SSD 6010 - One Residential Building (Student Accommodation) within Darling Drive Plot

Submission by:

Cavan & Mira Hogue

24 July 2013

SHADOW DIAGRAMS: PERSPECTIVE, SHOWING THE PEAK, WINTER SOLSTICE

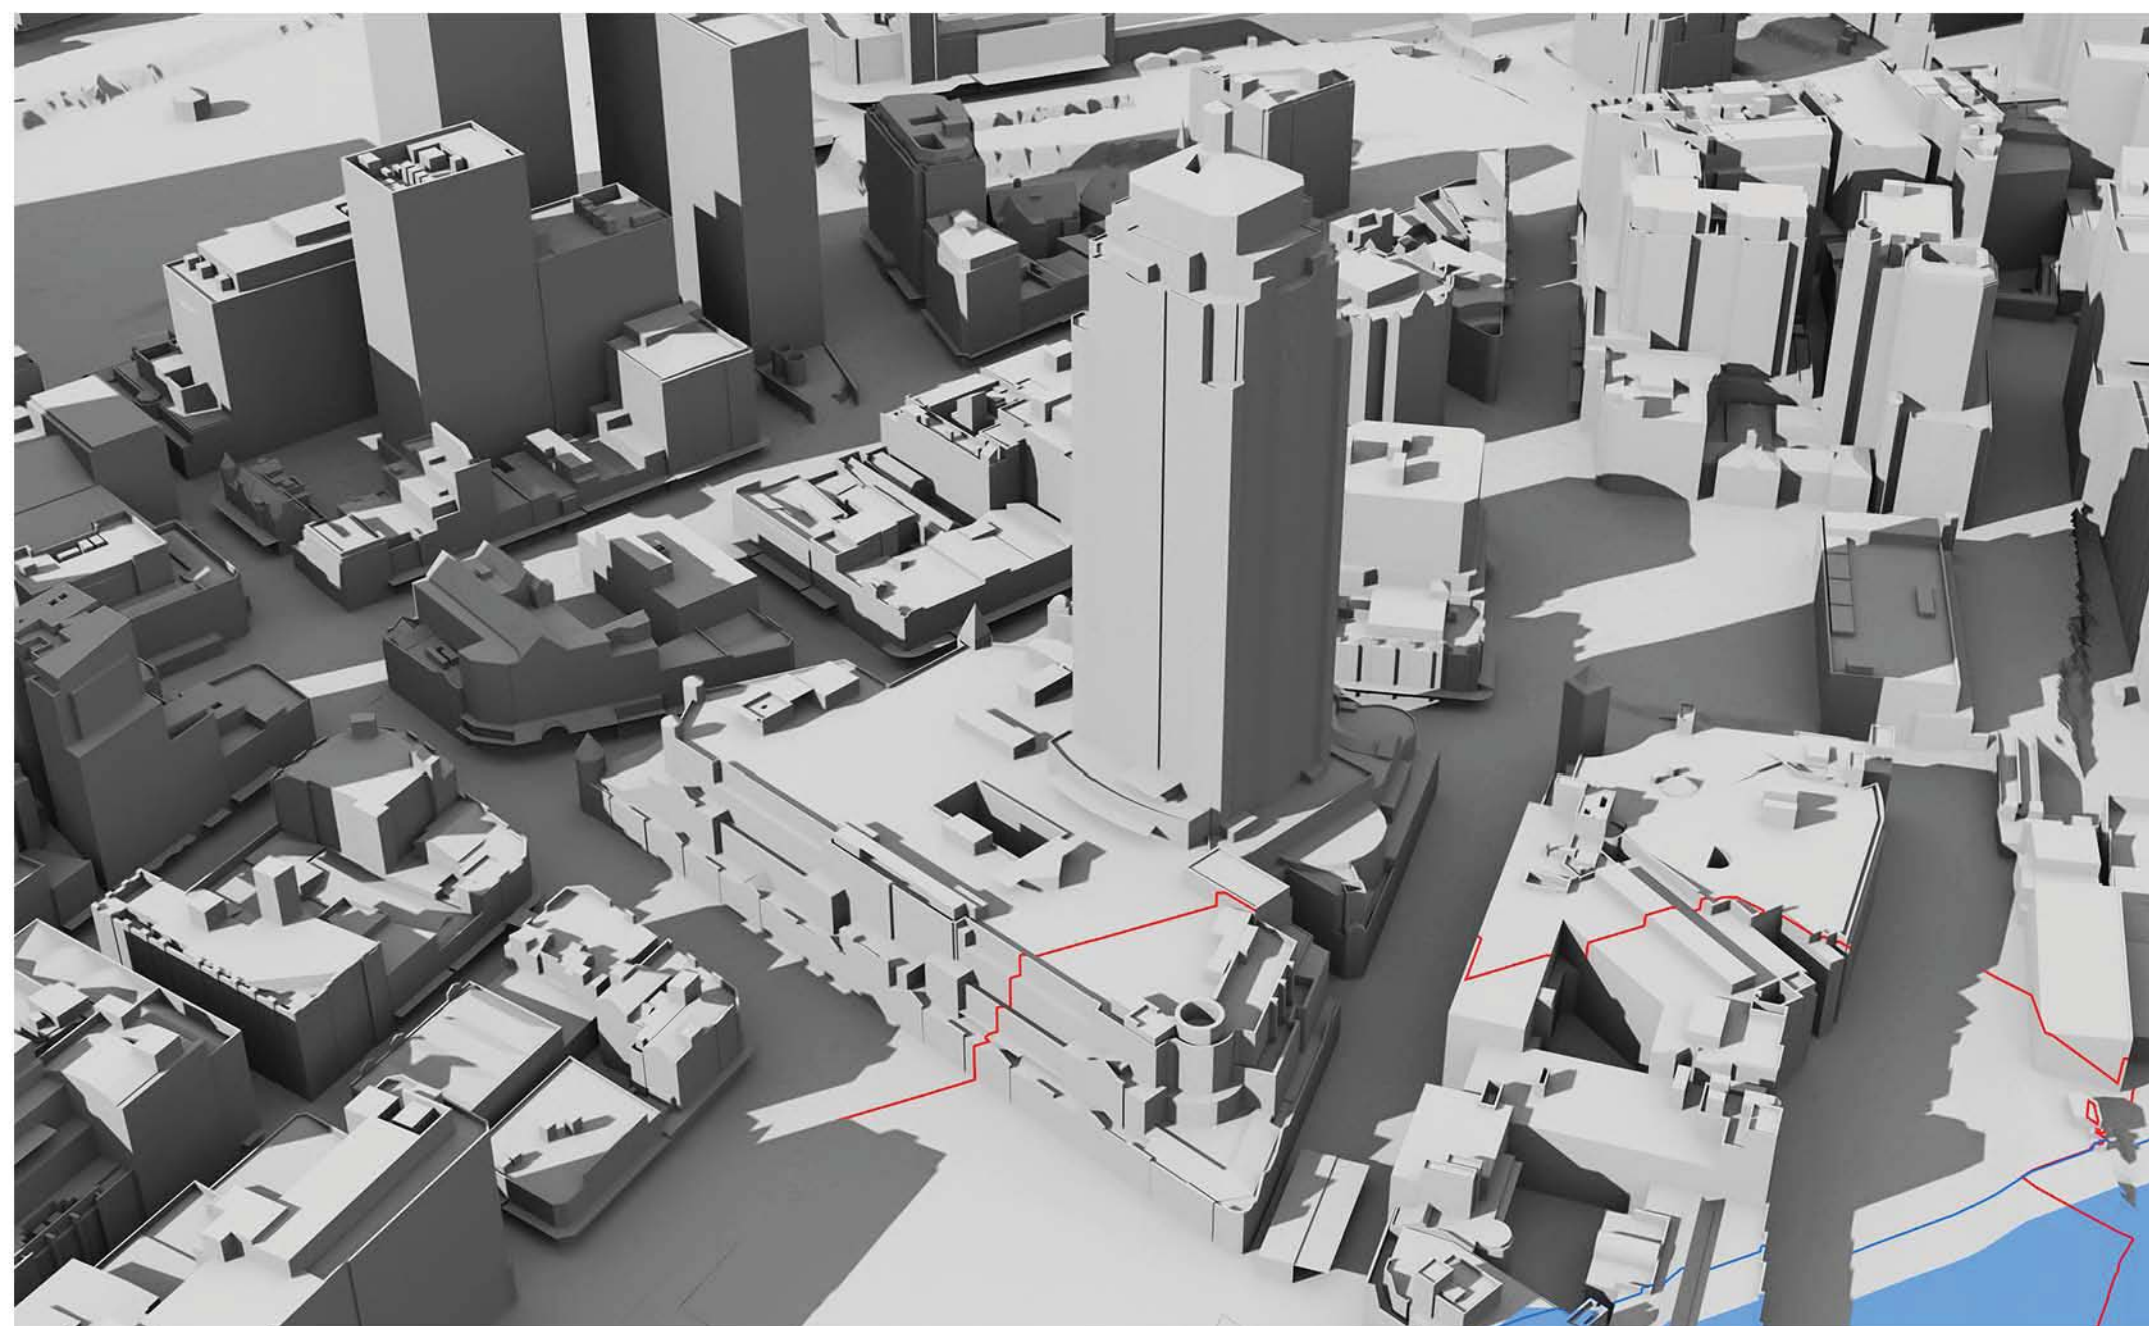
At 9am, 10am and 11am the west façade is totally in shadow due to other parts of The Peak building itself.

At 12pm there is still substantial existing shadowing on the west façade caused by the irregular shape of the west facade.

At 1pm the existing shadowing has been substantially removed, but not totally removed.

It can be concluded that some single aspect apartments on the west façade and some south-west dual aspect corner apartments currently receive less than 2 hours direct sunlight to habitable rooms and 50% of the private open space between 9am and 3pm on 21 June.

By 2pm the existing shadowing has been totally removed, but that is too late to achieve two hours of direct sunlight before 3pm.

At 9am, 10am and 11am the west façade is totally in shadow due to other parts of The Peak building itself.

At 12pm there is still substantial existing shadowing on the west façade caused by the irregular shape of the west facade.

At 1pm the existing shadowing has been substantially, although not entirely, removed. However, overshadowing of lower levels of the west façade by the concept proposal parameter plan shadows for the N,NE and SE plots has already started.

By 2pm the existing shadowing has been totally removed. However, overshadowing of the west façade by the SSDA4 and SSDA5 buildings has appeared and risen further up the west façade than the concept proposal parameter plan shadows for the N,NE and SE plots, which is still present.

At 3pm, the proponent states correctly that 45-45% of the western façade is overshadowed by the SSDA4 and SSDA5 buildings.

It can be concluded that, as a result of combination of the proposed development with existing shadowing of the west façade, some single aspect apartments on the west façade and the south-west dual aspect corner apartments which currently receive less than 2 hours direct sunlight to habitable rooms and 50% of the private open space between 9am and 3pm on 21 June will suffer additional overshadowing. It is beyond our skills to count the number of such apartments. We note that the proponent has made no attempt to do so.
